Longfield Solar Farm

Applicant Responses to ExA Further Written Questions

Document Reference : EN010118/EX/8.15(A)

Deadline 6

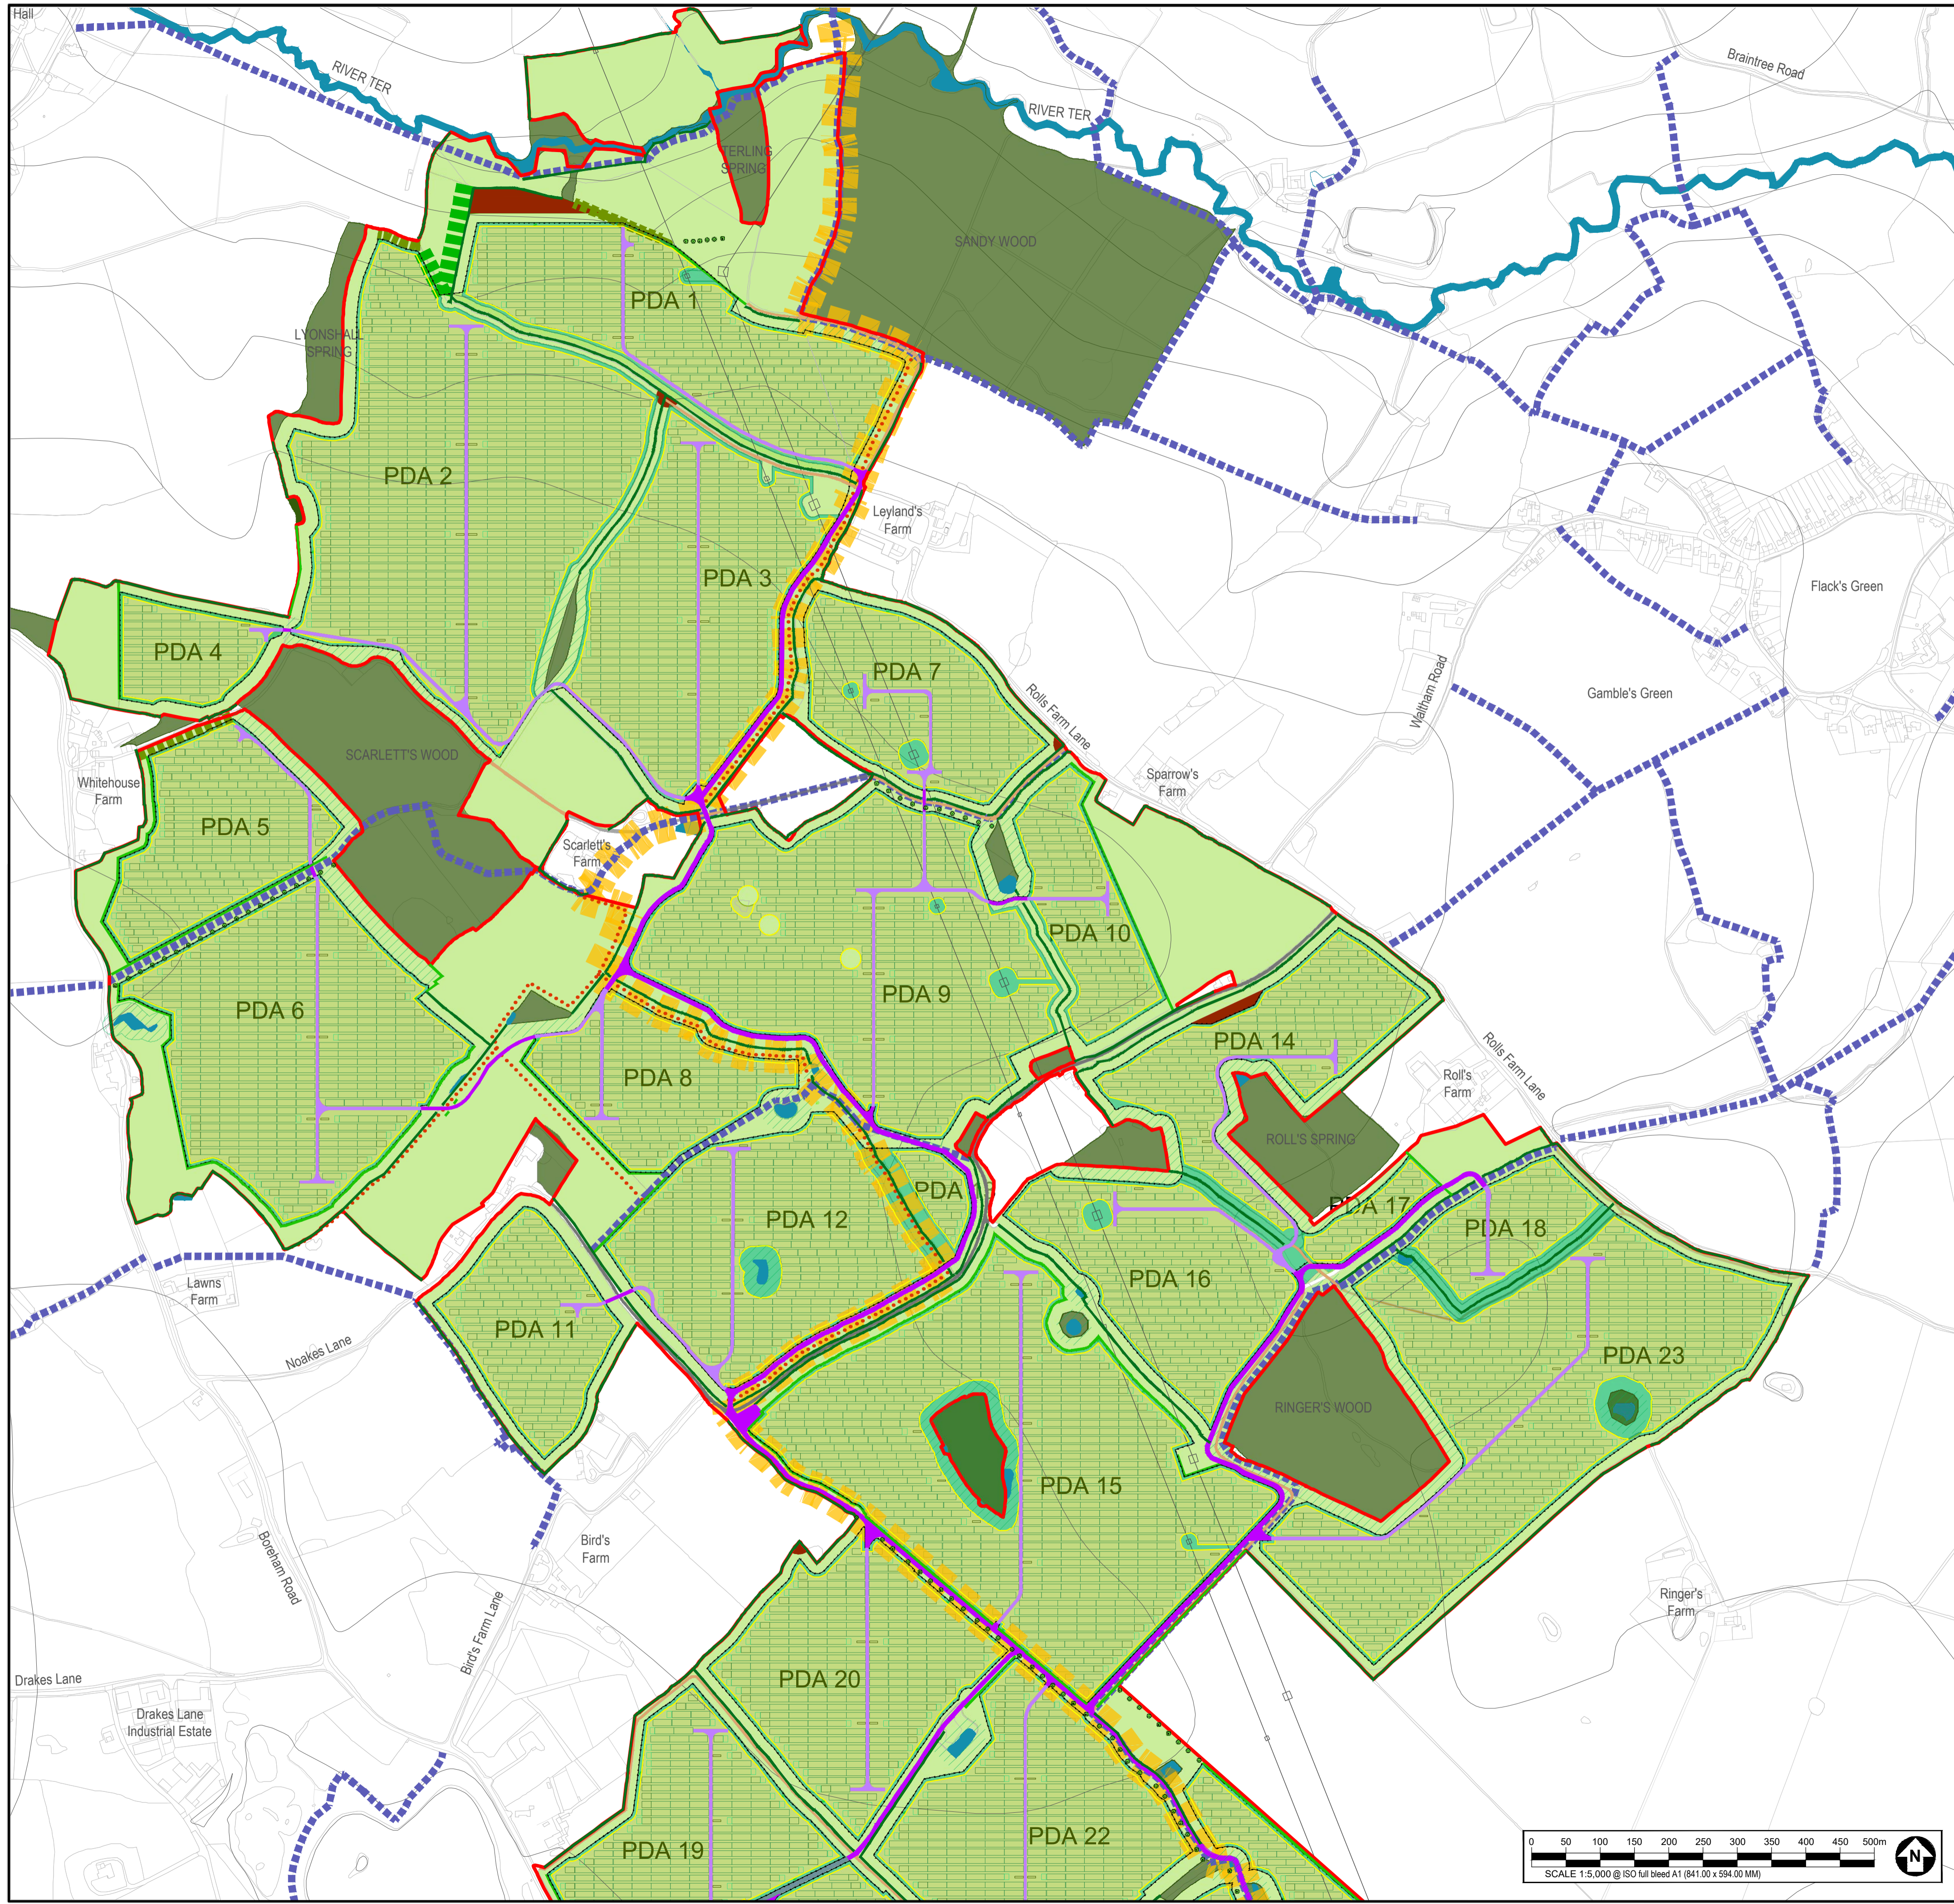
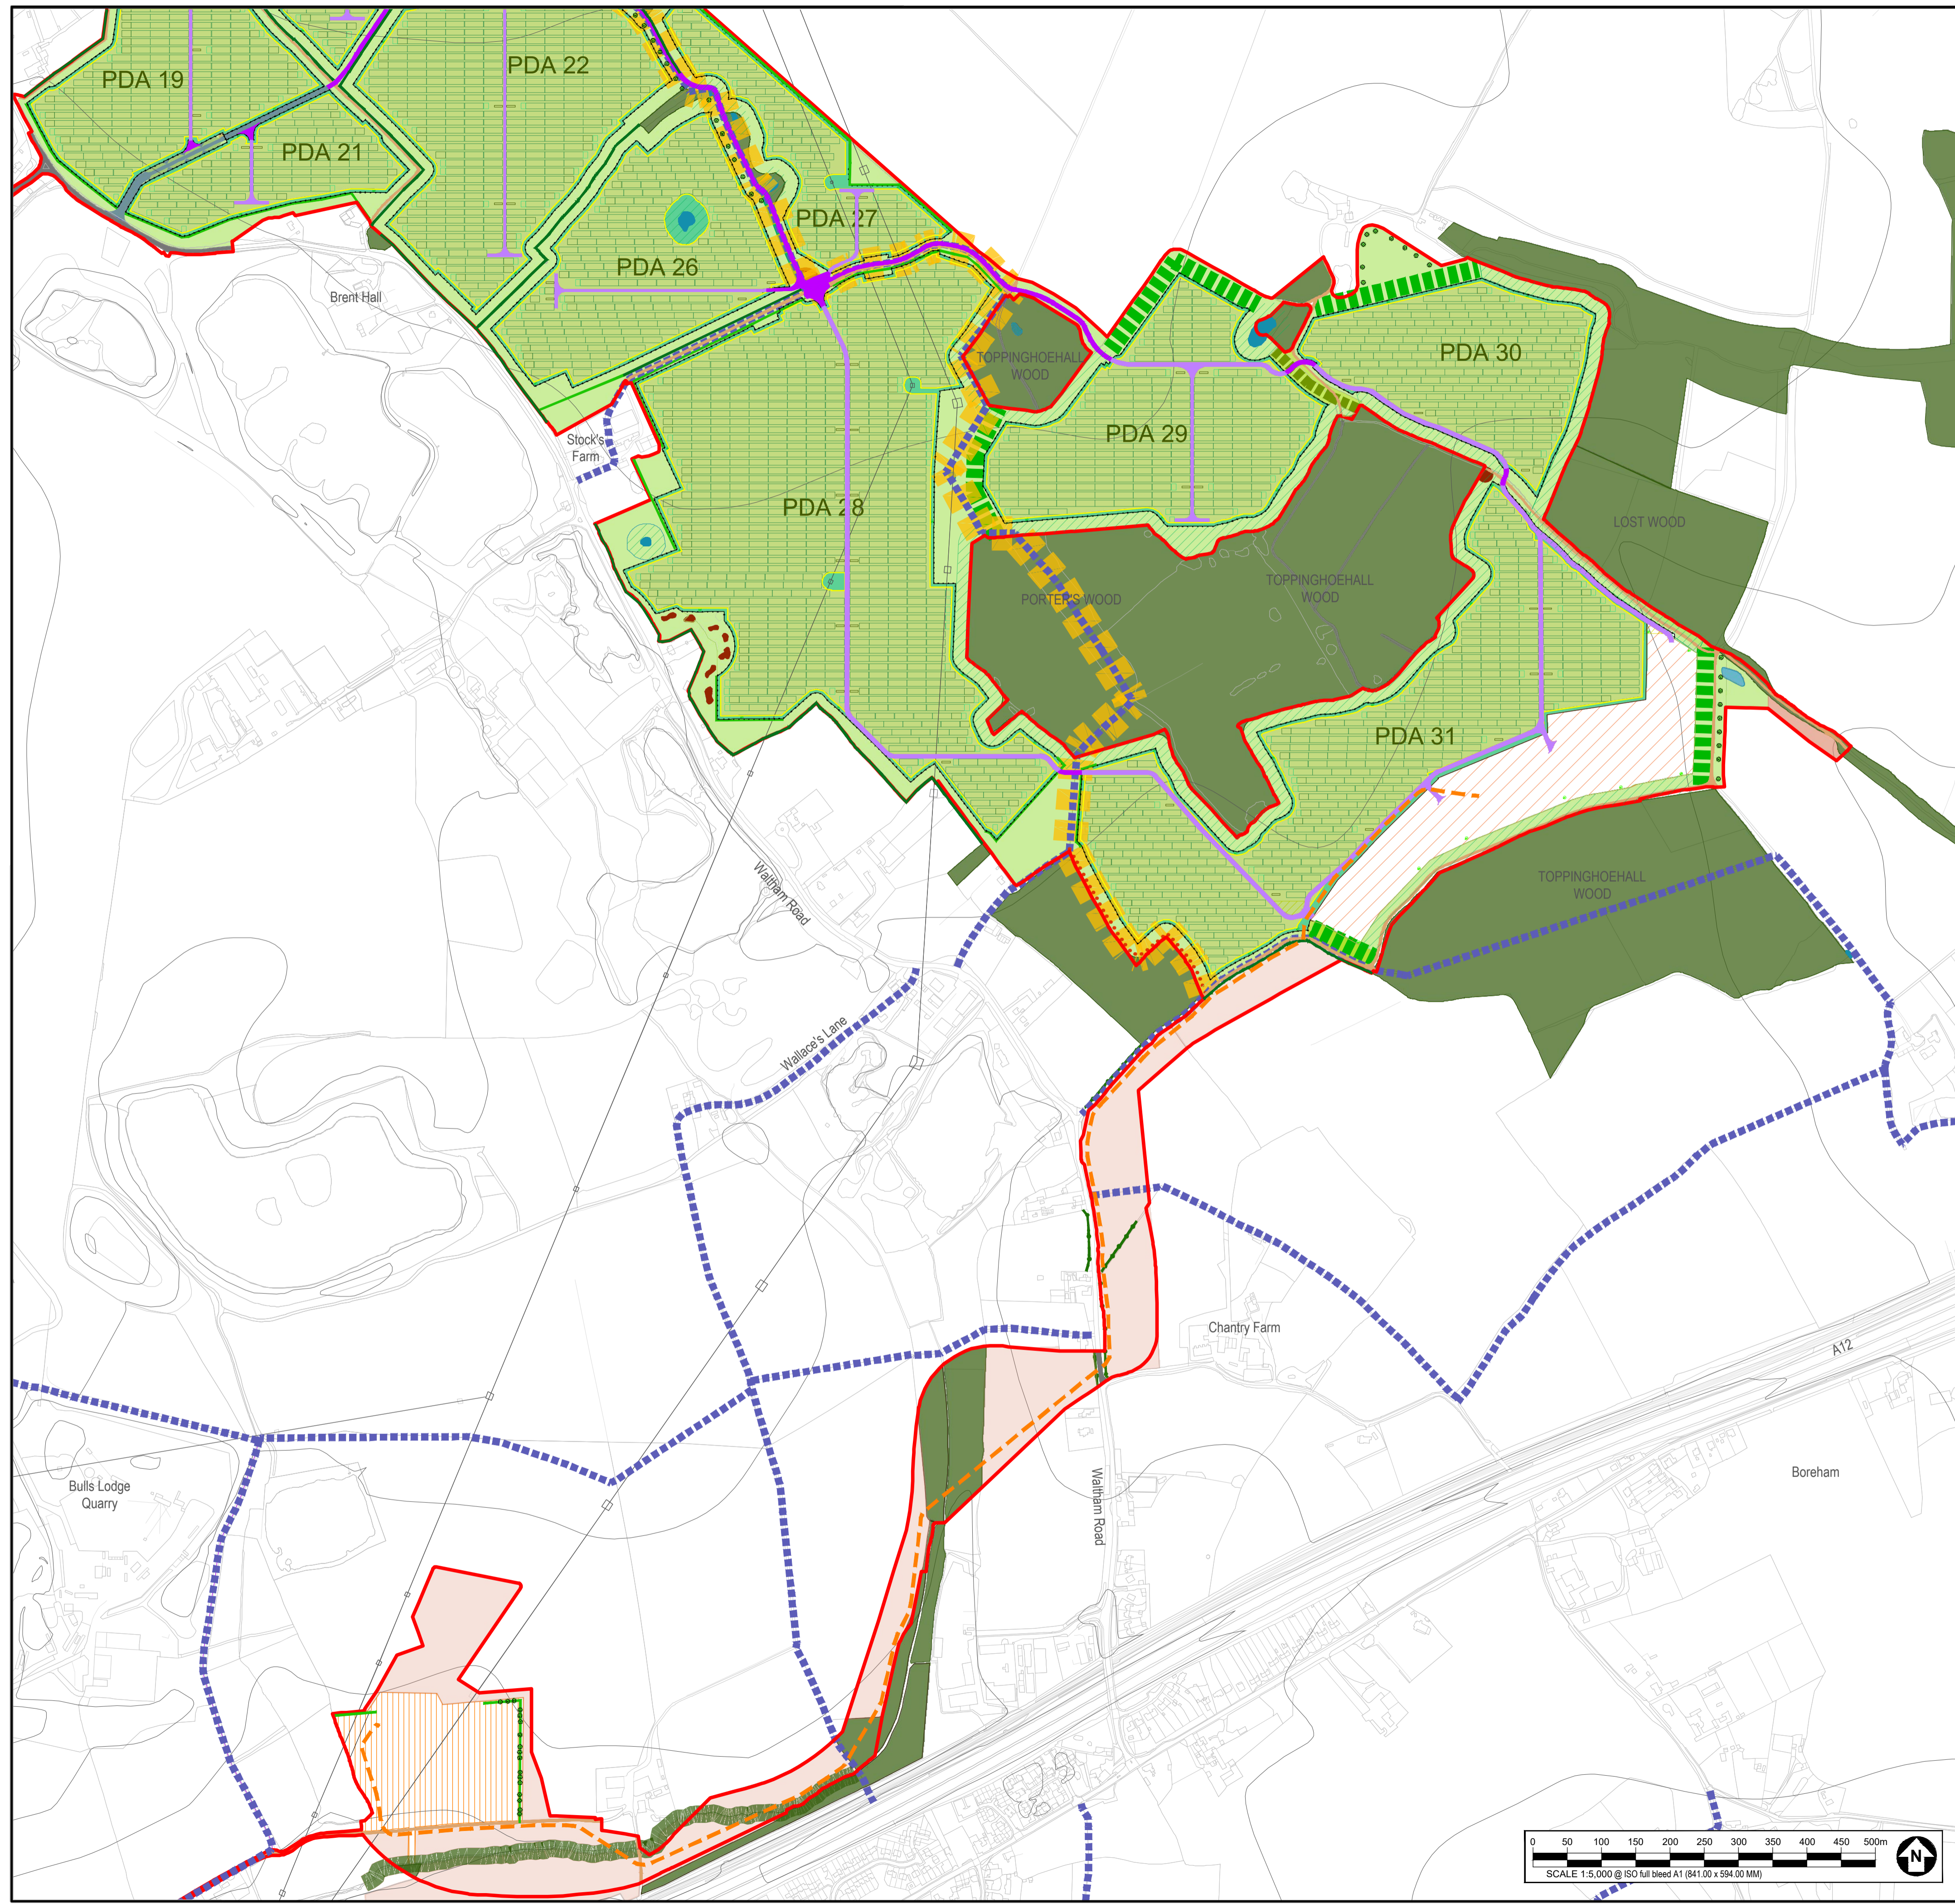
<p>3.2.8</p>	<p>Applicant</p>	<p>The ExA notes that the oLEMP submitted at Deadline 5 [REP5-006] does not include Annex A. Please provide a complete and fully consolidated version of the oLEMP.</p>	<p>This error has been <u>corrected</u> in the document and submitted at Deadline 6.</p>
